Description: To provide production facilities for the manufacture of pizzas, together with associated amenities and facilities

Location: Sluice Road
Holbeach St Marks

Amendment: Reduce size and amend design of reception area at western end of pizza building

**TOWN AND COUNTRY PLANNING ACT 1990
NOTICE OF ACCEPTANCE OF AMENDMENT**

DRAWING
CROSS SECTIONS

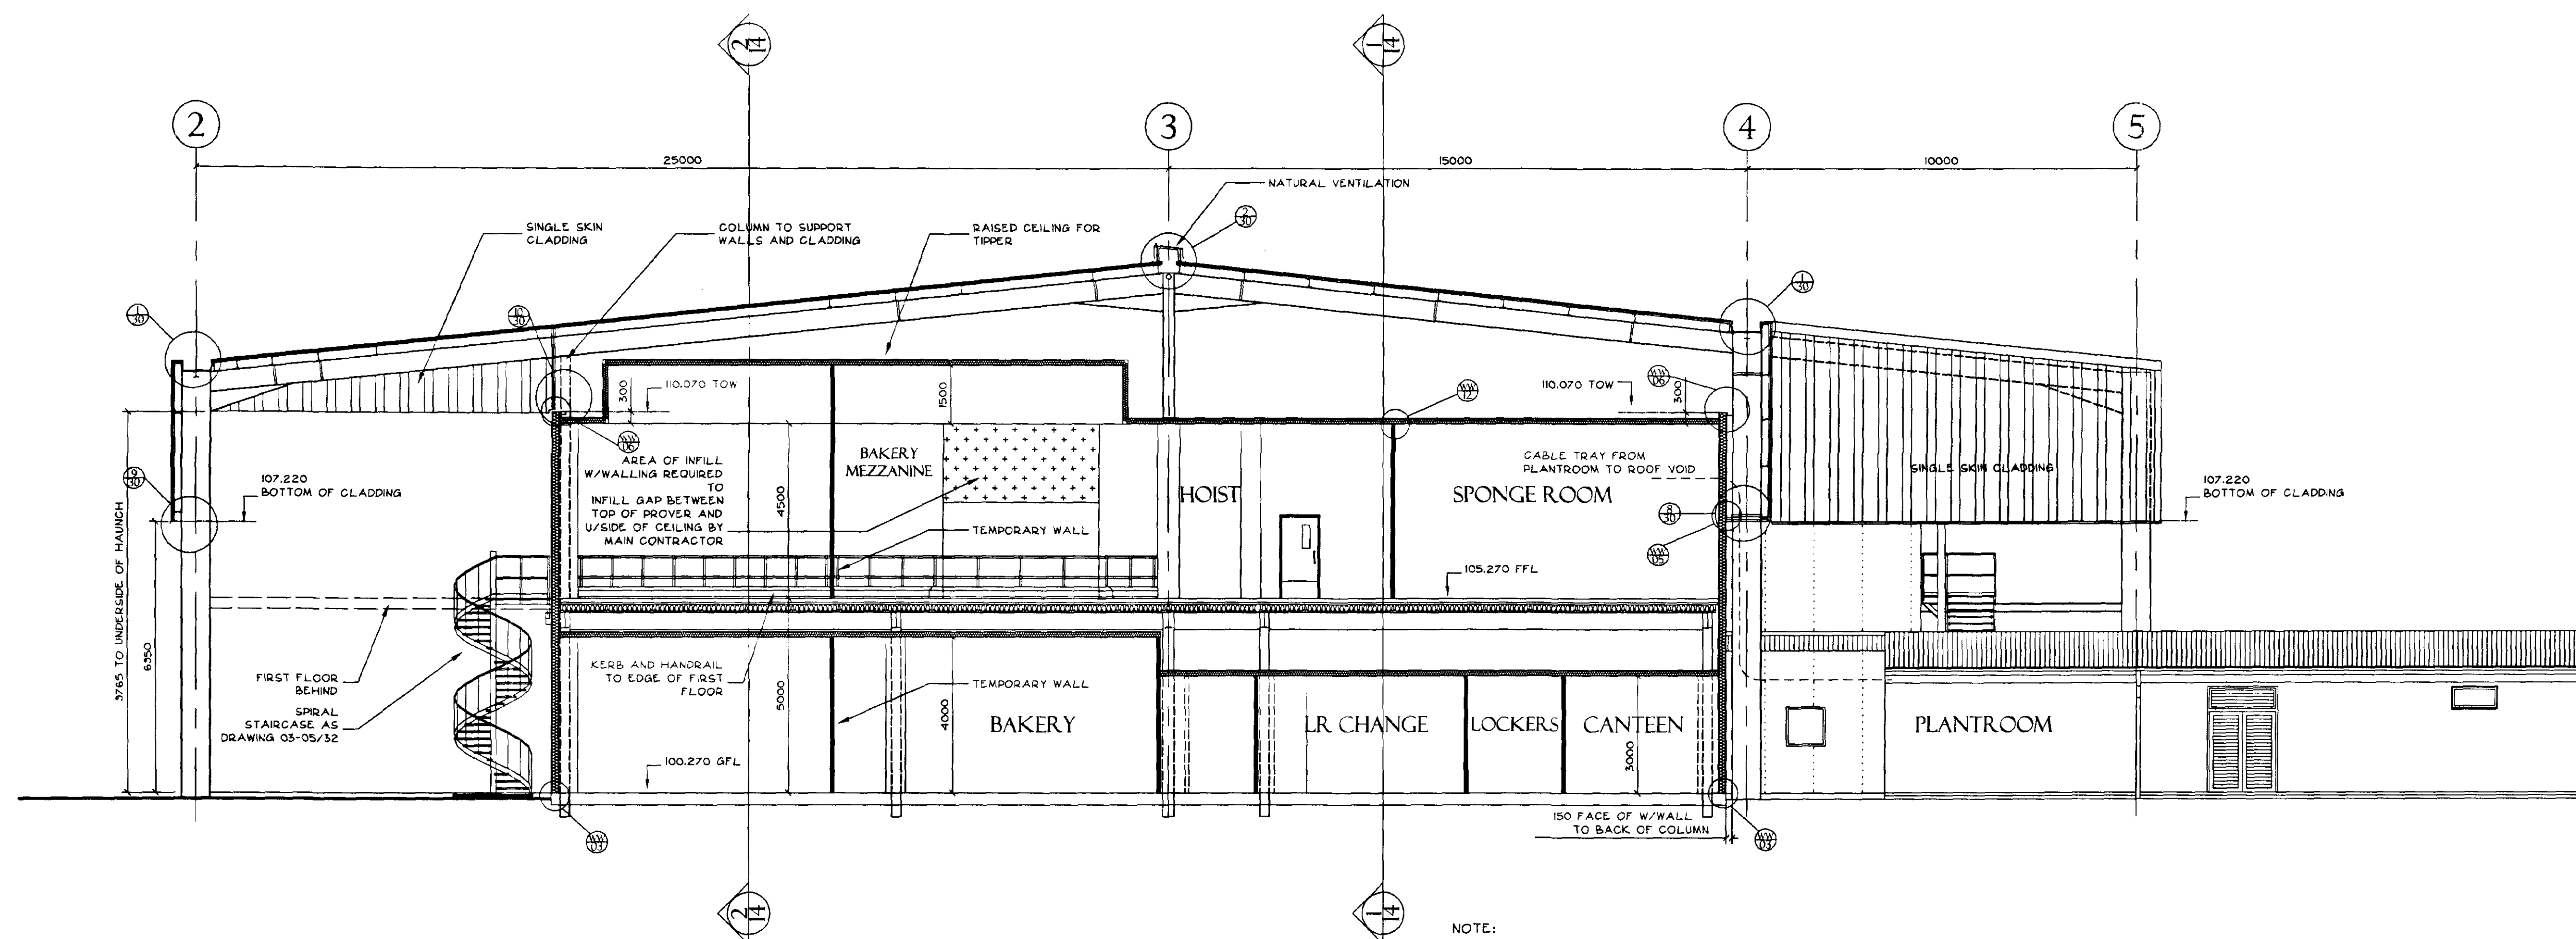
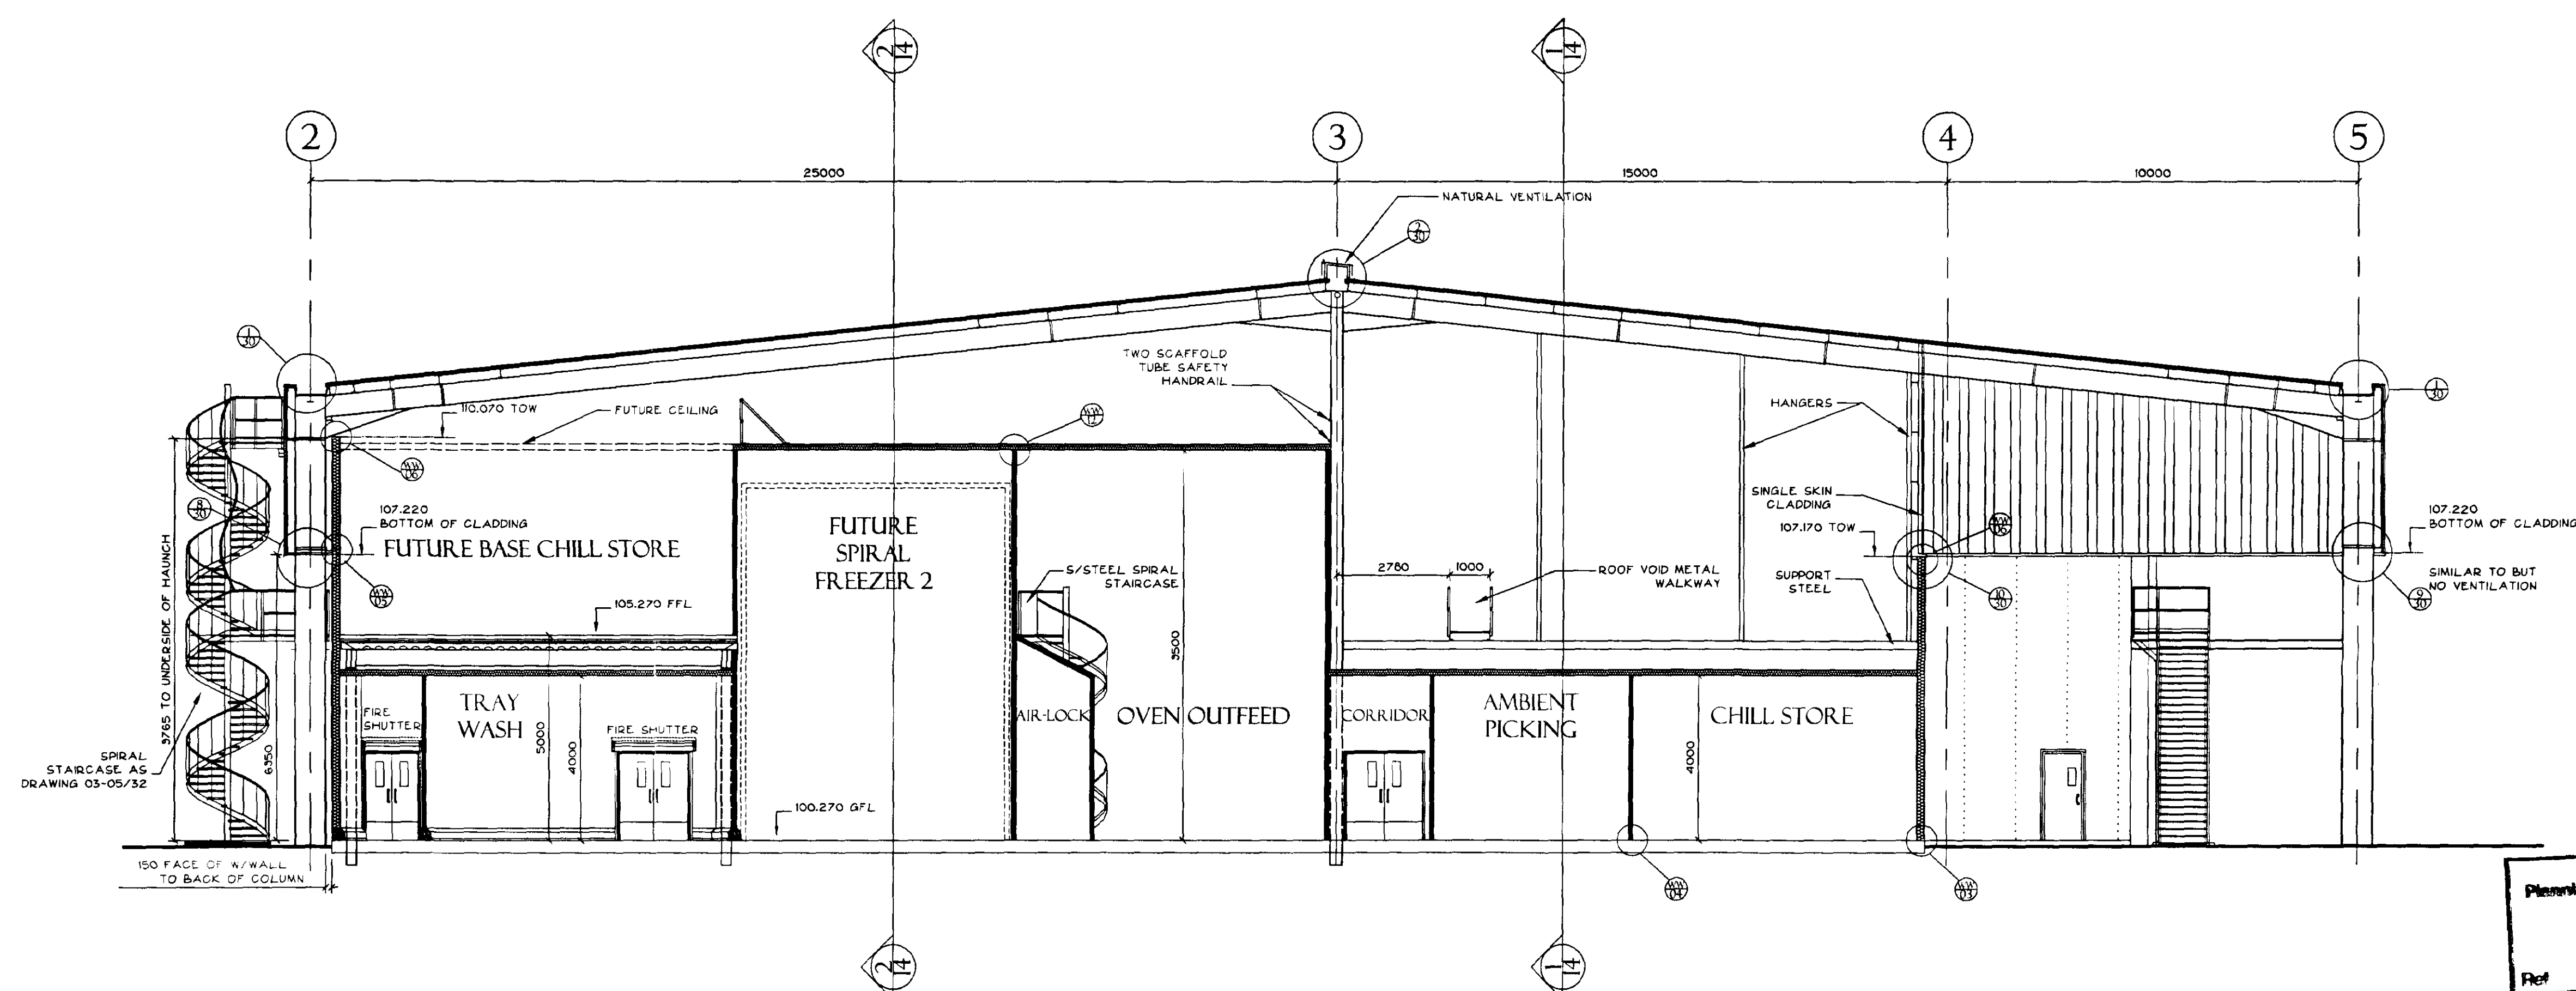
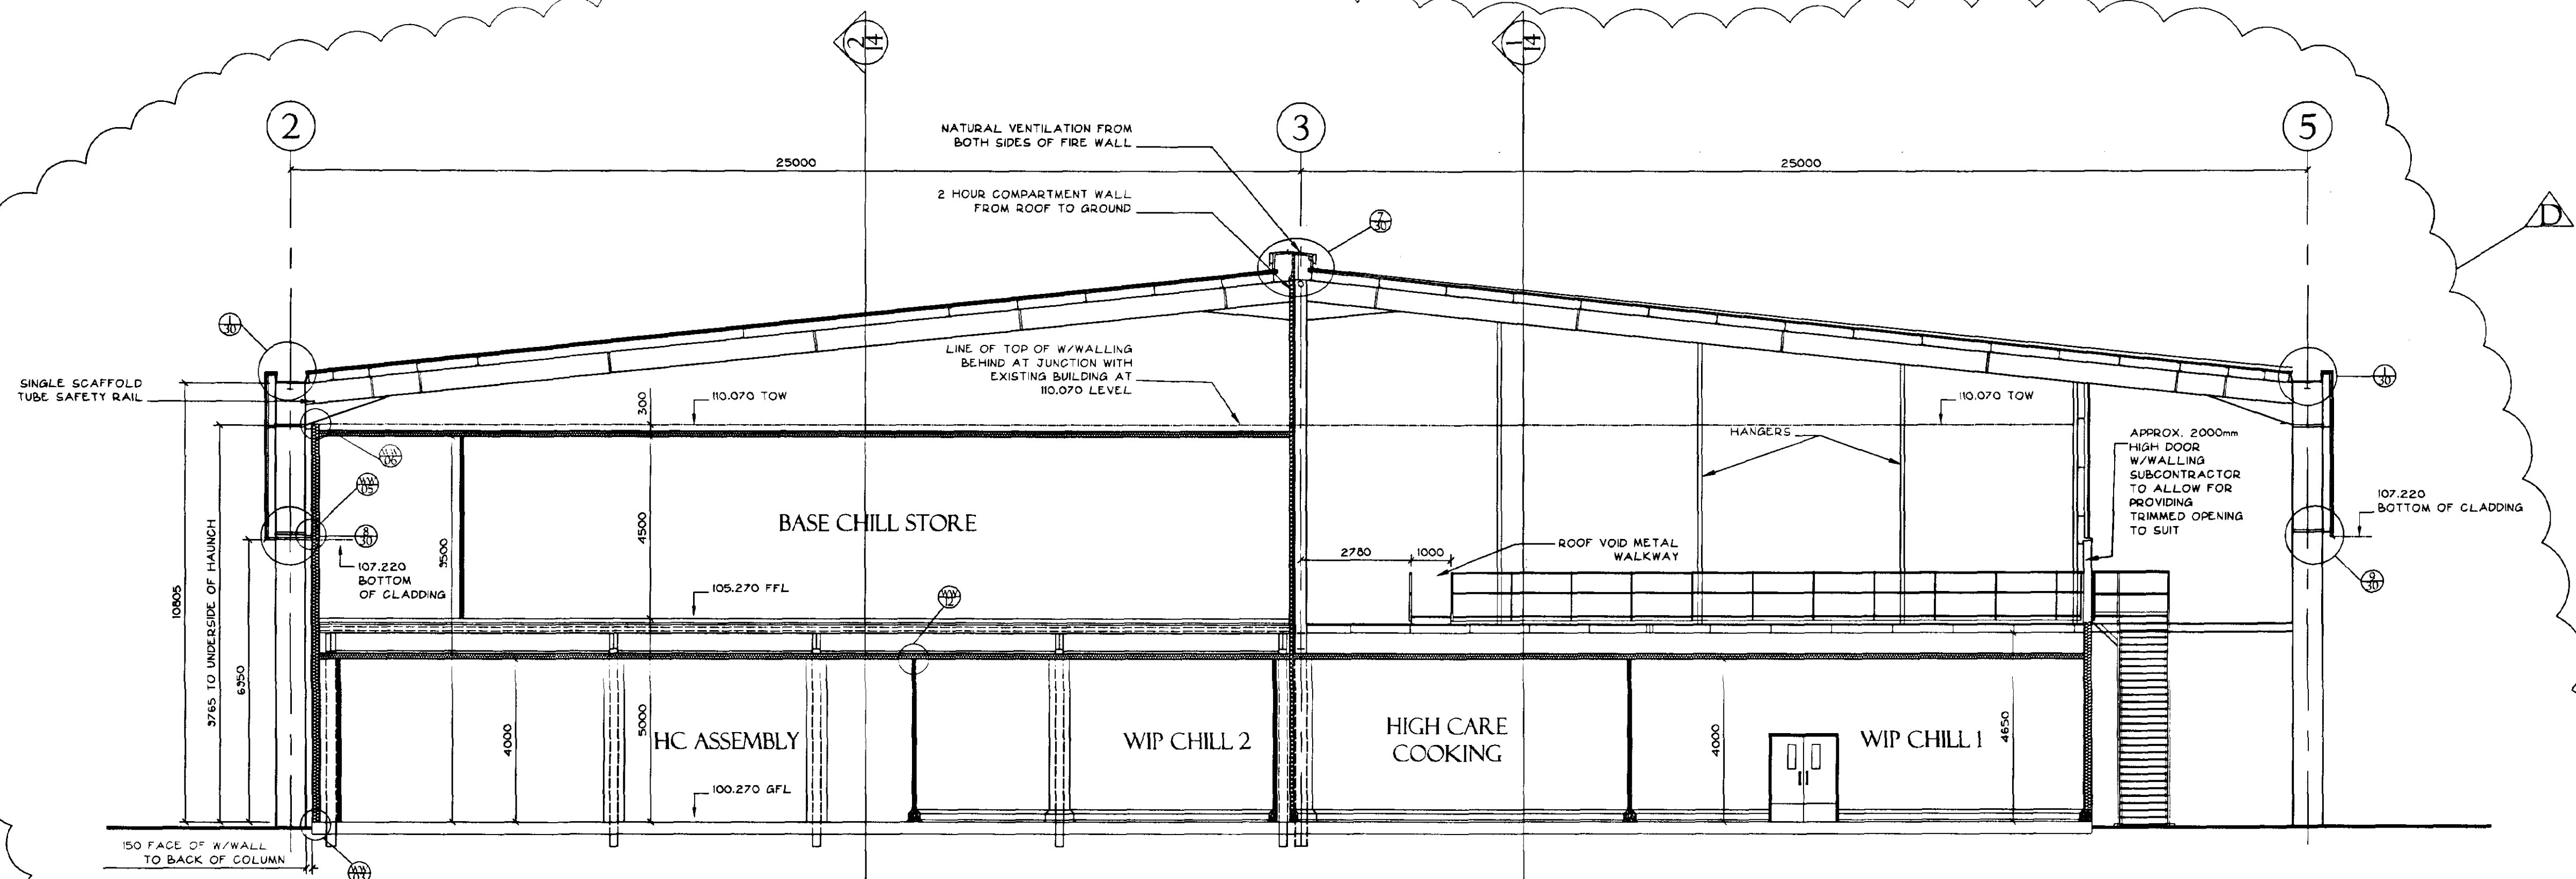
Amendment: Amended building design/layout including reduced height
Dwgs.03-05/02J;/03H;/04C;/05B;/10B;/12F;/13D & /14C

The major change from the original application drawings is the reduction in the main building height of about a metre.

The amended details submitted in respect of the above proposal have now been considered and there are no objections to the amendment being implemented to the extent described above.
